****** FIELD CHANGE LETTER ******

PROJECT #: 21-2816.1-A (Lot 102)

LOCATION: Lot 102, Duncan's Creek

PLANS REF: Holly – Plan 2 by South Designs
Project #: 21-2816.1(Farmhouse - RH) (sealed 8-5-24)

S-2.5.1

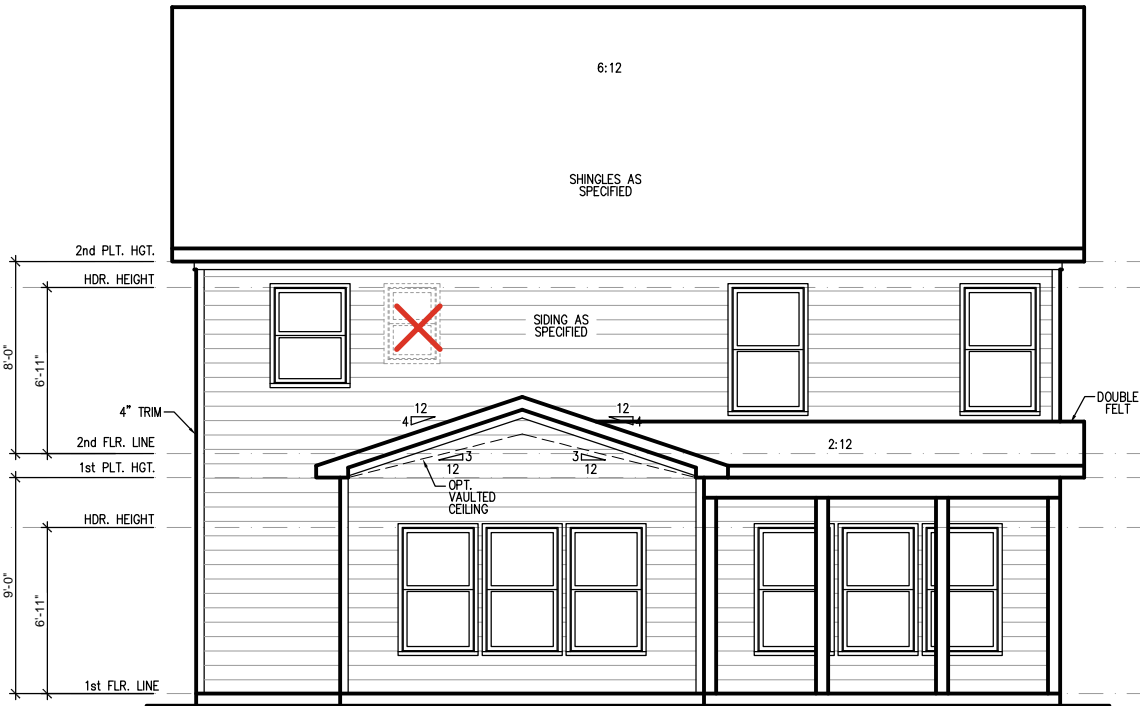
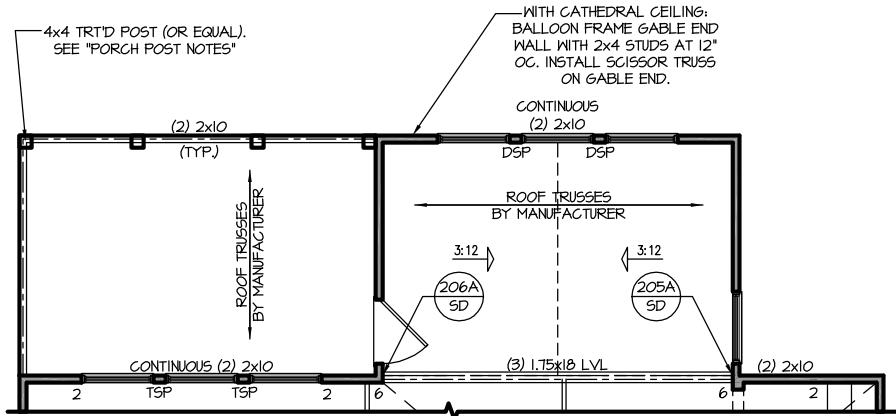
Extended Café – Gable End Wall Framing: The Extended Café option has a cathedral ceiling and sheet S-7.1 of the plans notes that the rear, gable end wall of the Extended Café is to be balloon framed with 2x4 studs at 12" O.C. Based on information provided to Southern Engineers, the wall was not balloon framed but was framed to a double 2x4 plate at the 9'-0" ceiling level. A triangular shaped kneewall was framed in between the top plate and the gable end scissor truss. A continuous (2)2x10 header was installed above the windows directly below the double 2x4 plate. The exterior of the wall is fully sheathed with WSP sheathing.

Response: Please note that the above described gable end wall of the Extended Café will be structurally acceptable provided that a minimum of (2)2x4 cripple studs are installed above the stud pockets between windows and above the jack studs at each end of the header. The cripple studs shall be attached to the stud pockets and jack studs with (2) vertical, Simpson CS16 straps at each column location. The straps shall extend down from the bottom of the truss and shall extend least 16" down the lower stud columns. .
